London Luton Airport Expansion

Buckinghamshire Council Response to the Applicant's Response to Deadline 6 Submissions 6

PINS REFERENCE: TR020001

January 2024

Inset 2-1: The incremental effect of Jet Zero Strategy mitigation policies on Aviation emissions

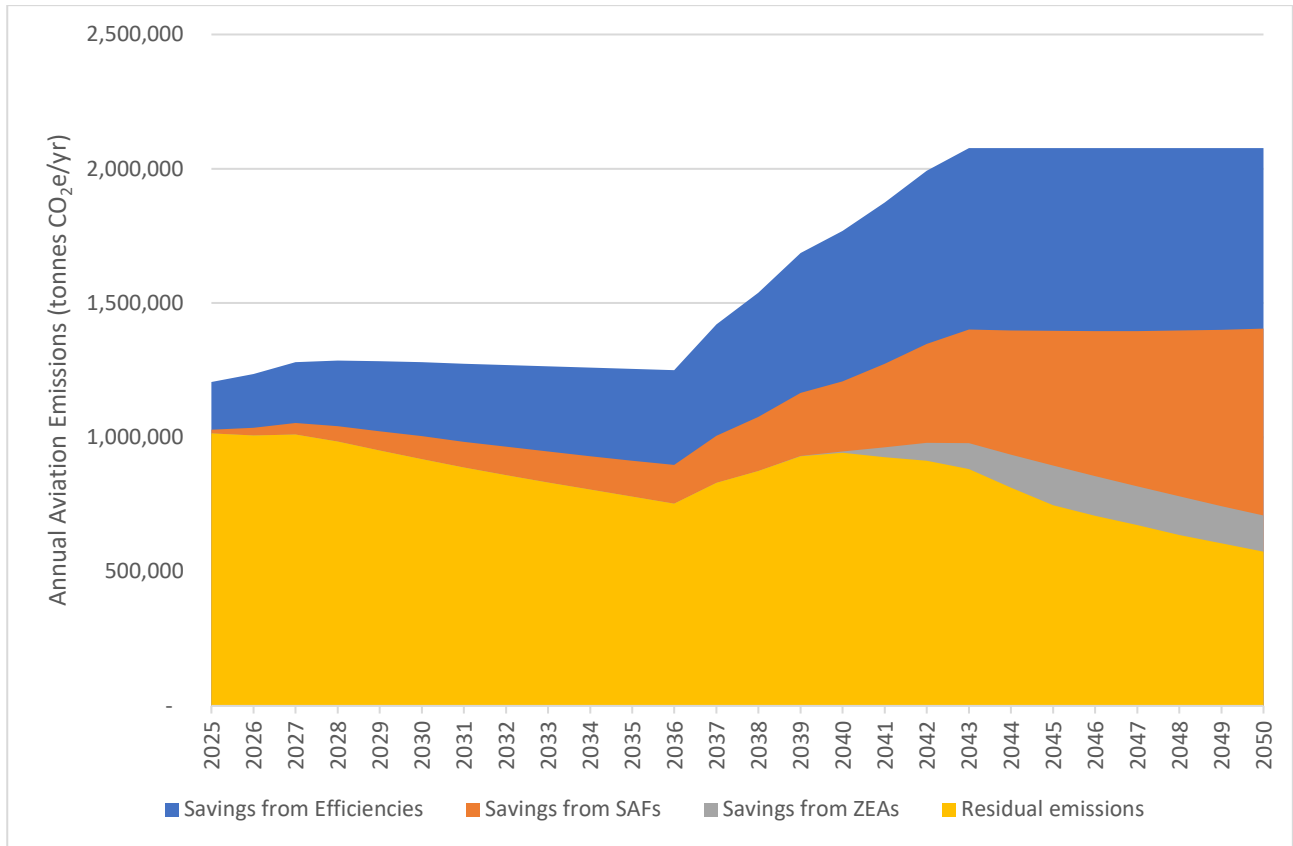
3.1 6	Greenhouse gases and Climate Change	<p>Inset 12.4 of Chapter 12 of the Environmental Statement (“the ES”), Greenhouse Gases (“GHG”), which is entitled “The incremental effect of Jet Zero Strategy mitigation policies on Aviation Emissions” [REP3-007, p.68] has been referred to at times as a sensitivity study. However, it merely shows the different contributions of measures to the total aviation GHG emissions reductions through to 2050. It is not and should not be understood as a sensitivity study, (see [REP5-064, §2.40]).</p>	<p>The Applicant stands by the response in the Applicant’s Response to Deadline 5 Submissions Appendix B – Buckinghamshire Council [REP6-055], and reiterates the acceptance that the analysis does not constitute a quantitative sensitivity analysis, rather a proxy for it. Please refer to REP6-055.</p>	<p>BC makes no further comments on this matter.</p>

Figure 7 – Dunstable Leighton Buzzard Screenline Count Locations

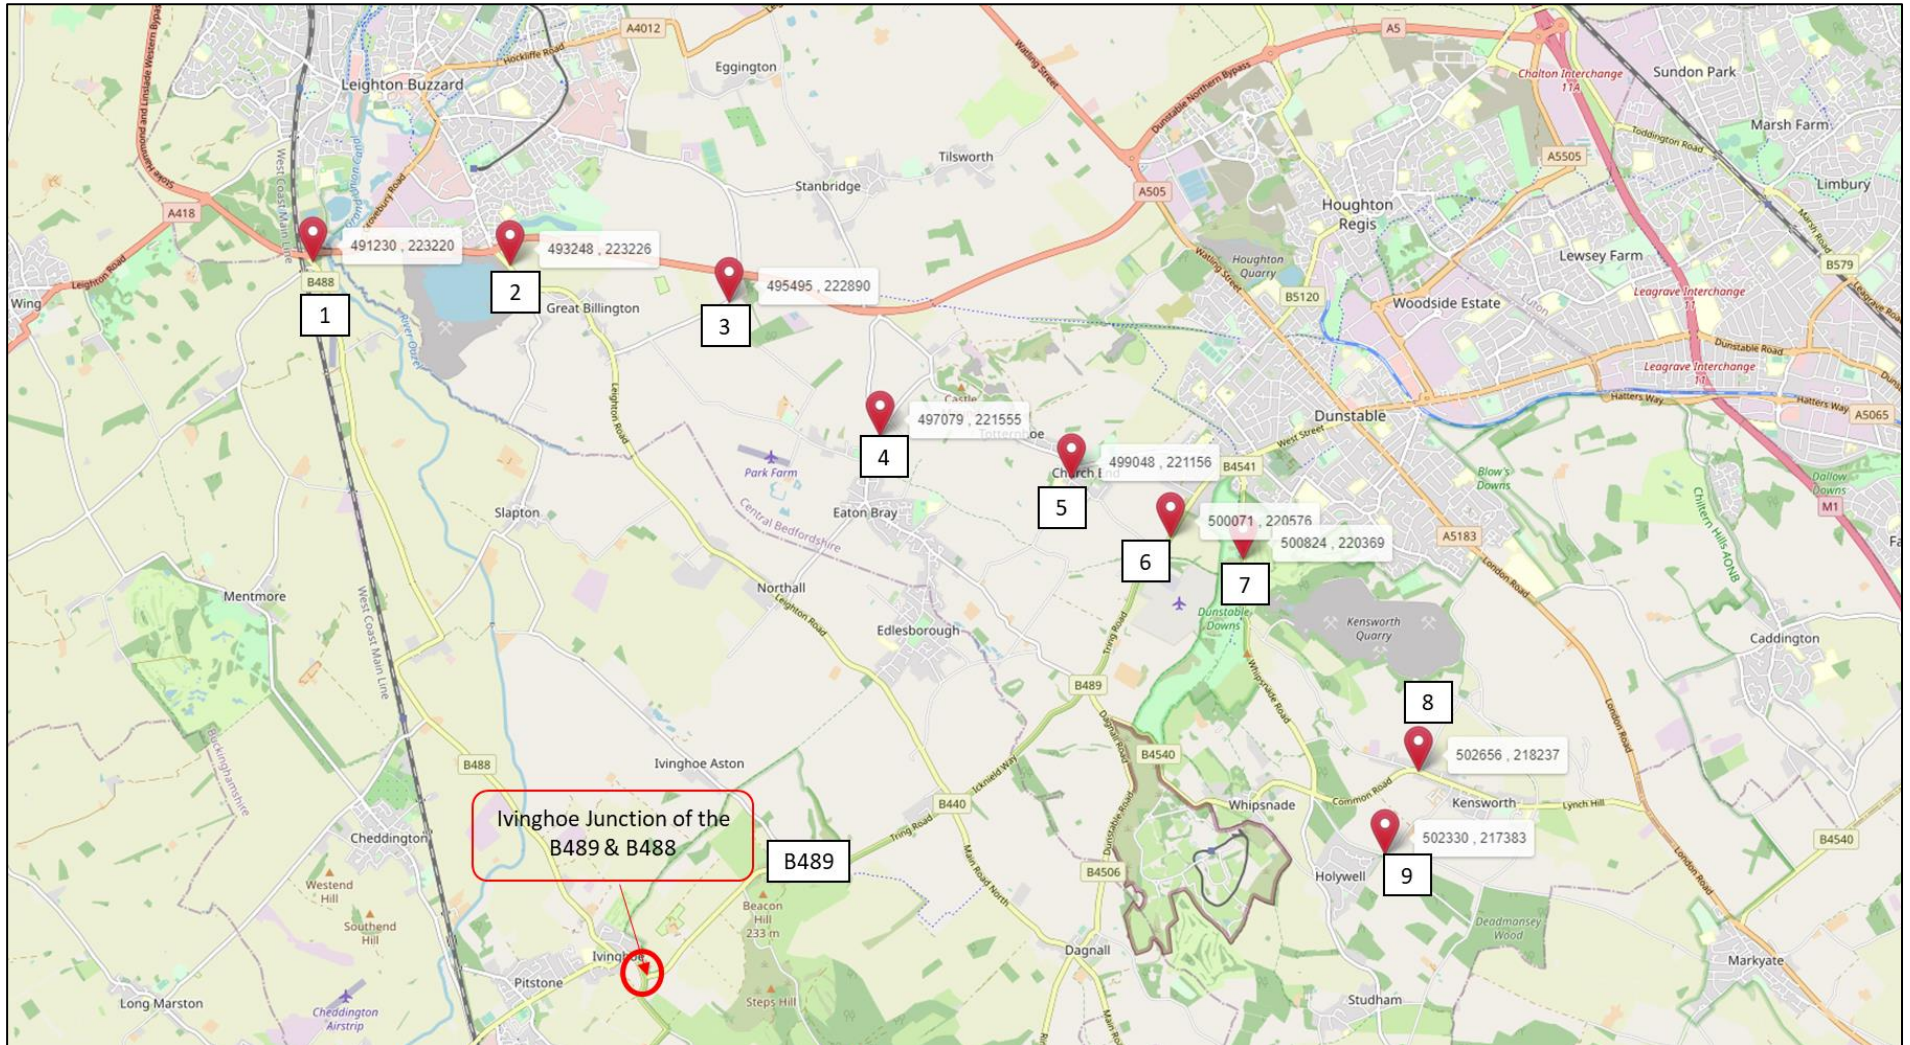
<p>3.2</p>	<p>Surface Access</p>	<p>At the hearing, the Applicant suggested that there had been a validation exercise in relation to a screen line south from Leighton Buzzard and that this was a good proxy for Bucks. BC is not satisfied that this suitably addresses its concerns.</p> <p>Bucks falls outside of the area that has been informed through survey data (but within the area informed by mobile phone data). As a result, the modelling is not as detailed in Bucks as it is in relation to the Luton and Central Bedfordshire areas. Strategic models become less accurate as one moves away from the central area which is fully modelled. The Dunstable –Leighton Buzzard screenline sits significantly to the east of the area of concern to BC. BC is not content that it can be confident of the accuracy of the model in relation to the B489 corridor and the Dunstable - Leighton Buzzard screenline does not provide validation in relation to this area of concern.</p> <p>BC is not requesting significant work from the Applicant in this area: the validation being requested is a comparison exercise between the modelled flows on the B489 in the base year against the actual flows obtained through the BC's ATC surveys which have been made available to the Applicant.</p>	<p>The Applicant mentioned that the Dunstable Leighton Buzzard Screenline contains several links that accommodate traffic travelling east-west to and from the Buckinghamshire area.</p> <p>The fact that the screenline performed well in accordance with the DfT TAG guidance on model calibration/validation, gives the confidence that the model is an appropriate tool to assess the relative change in traffic of the Proposed Development on Buckinghamshire's road network, and in particular, along the B489 corridor. More detailed information in relation to the validation of the individual roads across the screenline is reported in the Applicant's Response to Applicant's Response to Issue Specific Hearing 7 Action 3 -Ivinghoe Junction Modelling Review [REP6-070].</p> <p>As mentioned in the above response at ID 3.1, the Applicant considers it is not appropriate to compare 2023 data with a 2016 base year model.</p>	<p>The submission of the Ivinghoe Junction Modelling Review has been welcome. BC has been able to review the data for the B489 and is satisfied that the screenline information remains an accurate representation of the B489 within the Buckinghamshire area.</p>
